From: [ECY RE CRO SEPA Coordinator](#)
To: [Chace Pedersen](#)
Subject: SEPA 202305434 comments for CU-23-00002 (additional response letter)
Date: Friday, December 1, 2023 2:20:40 PM
Attachments: [202305434 Kittitas The Outpost.pdf](#)

RE: 202305434; CU-23-00002

Thank you again for the opportunity to comment during the Notice of Application process for The Outpost. The Department of Ecology (Ecology) would like to add the following comment, this is in addition to our November 29, 2023 response letter.

**CONCEPTUAL SITE PLAN
MULTIPLE PARCELS**

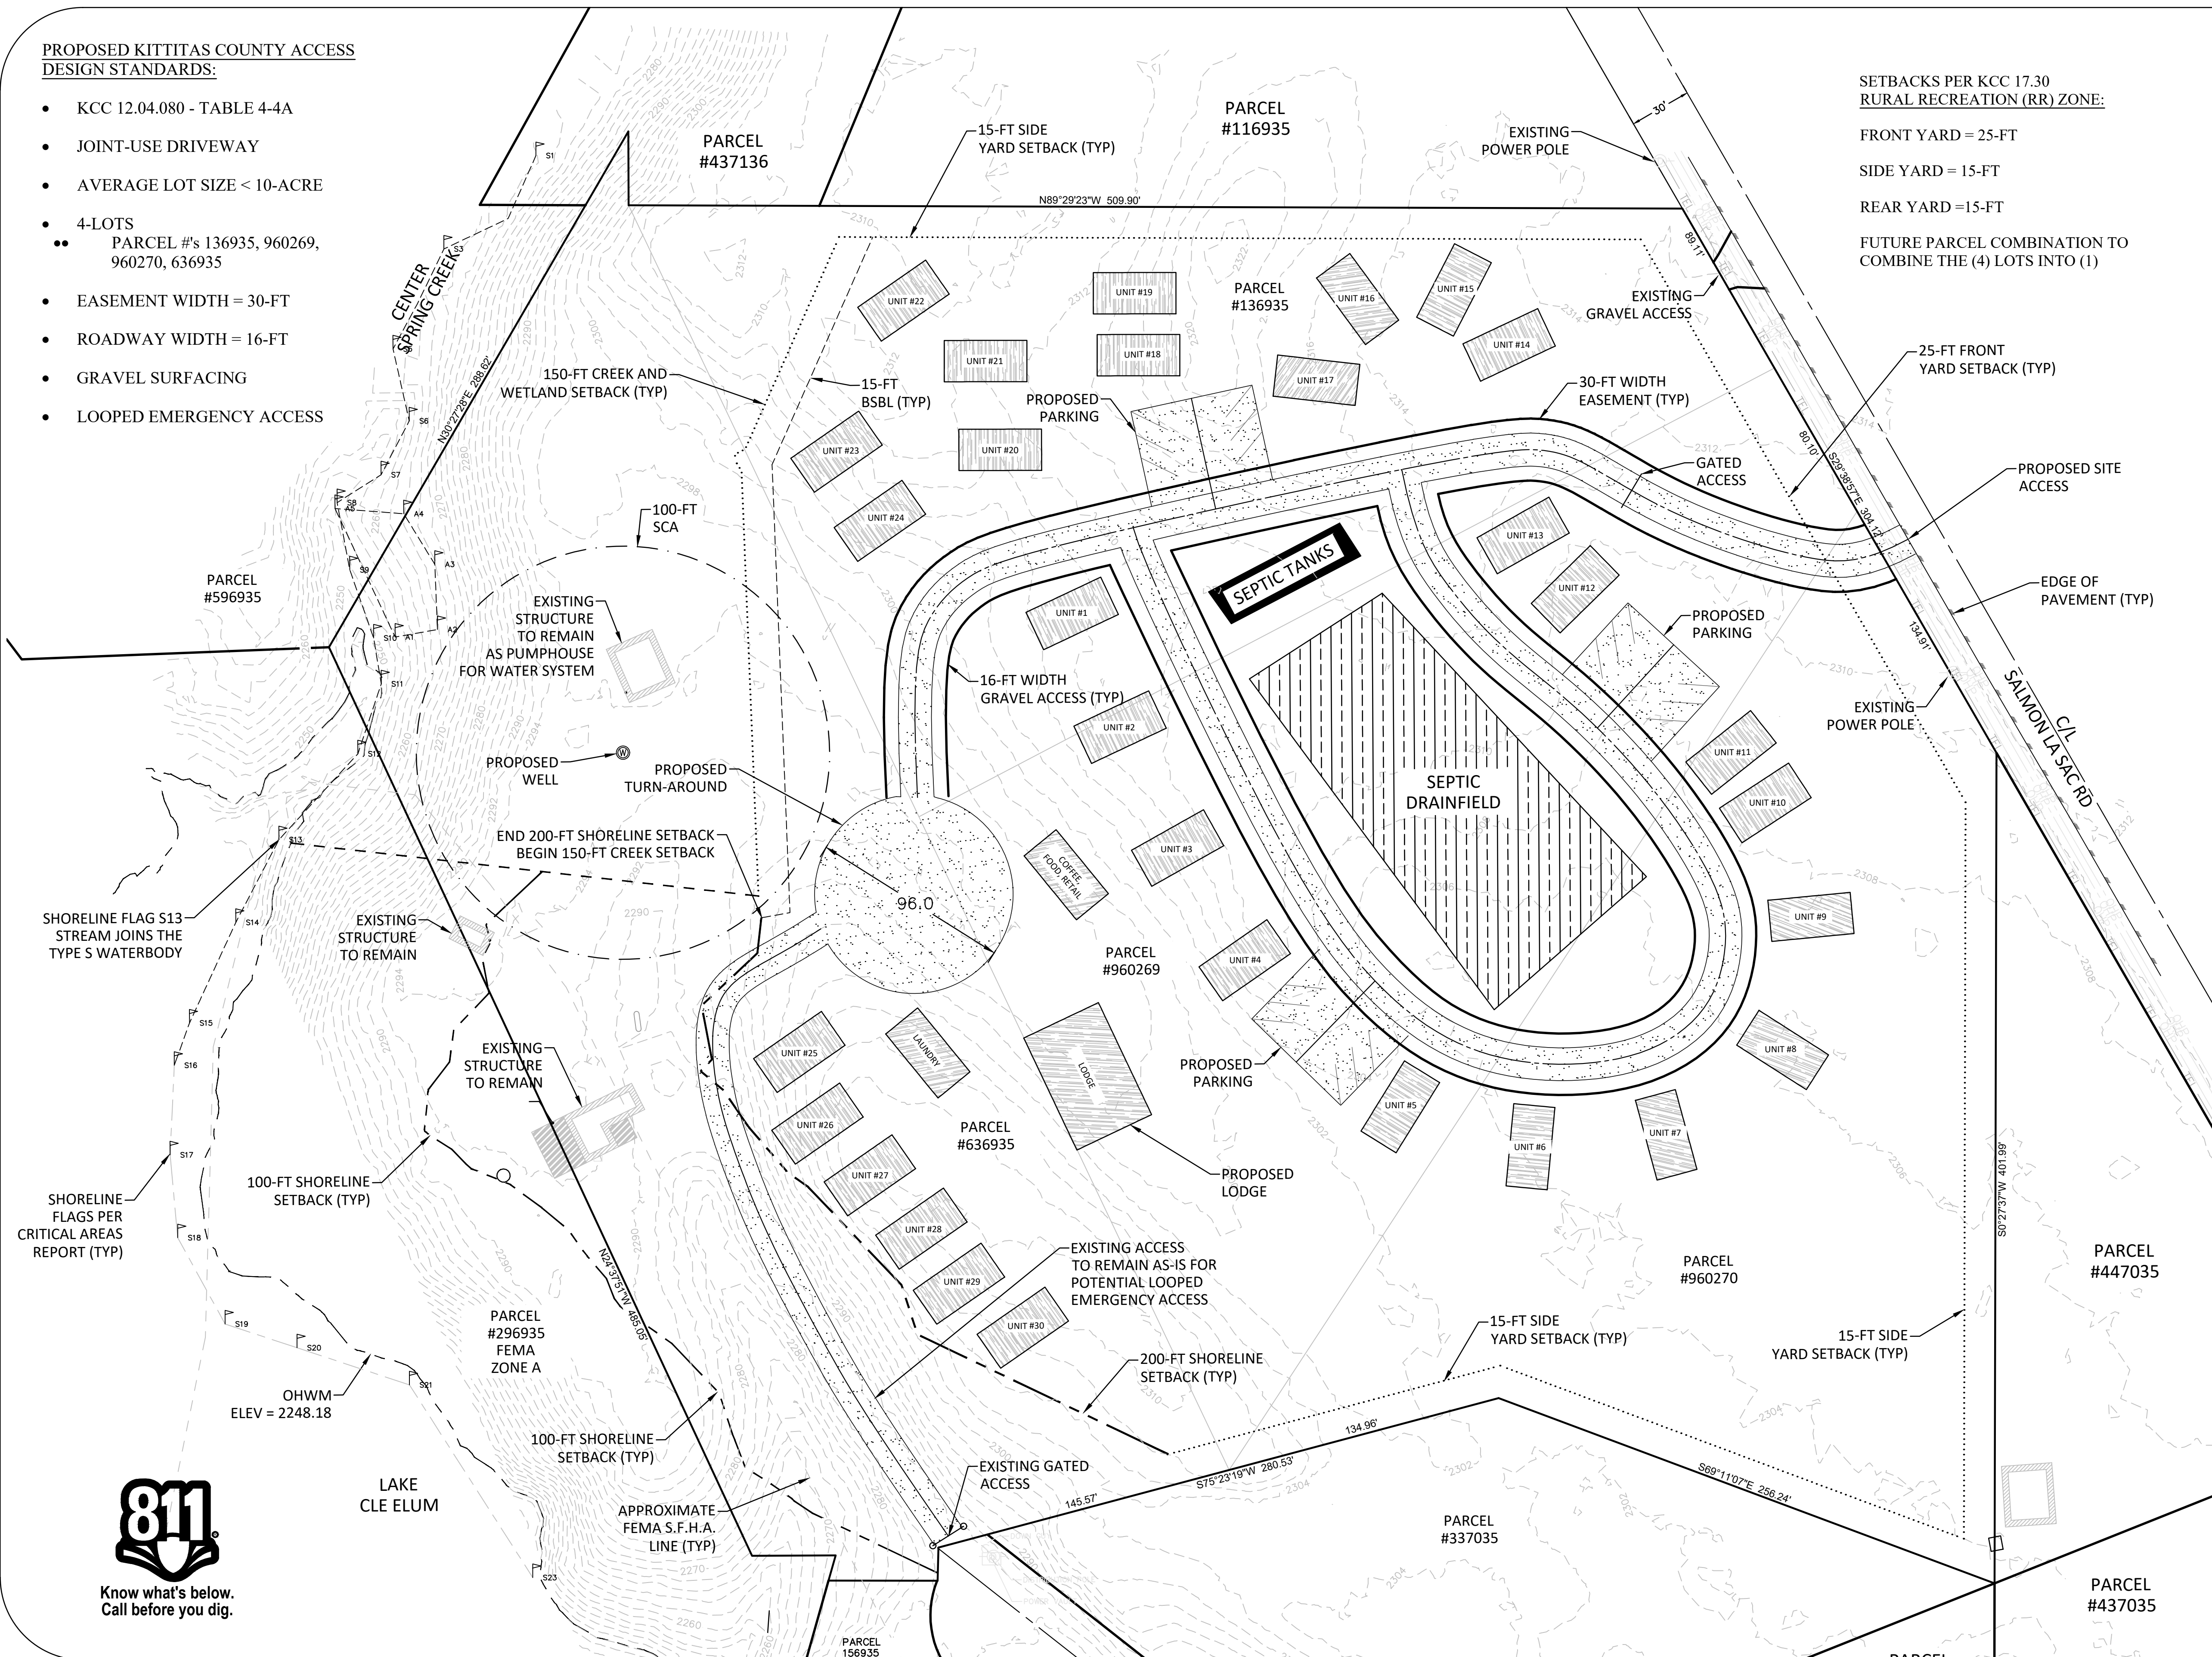
The Critical Area Report identifies a wetland on site that drains to Lake Cle Elum and identifies the Shoreline of Lake Cle Elum as a Shoreline Environment with a Residential use designation. The wetland is described as hydrologically connected to Lake Cle Elum, so the shoreline jurisdiction extends to include the wetland. Any development within the shoreline environment must adhere to the Kittitas County Shoreline Management Program and the Washington State Shoreline Management Act (RCW 90.580).
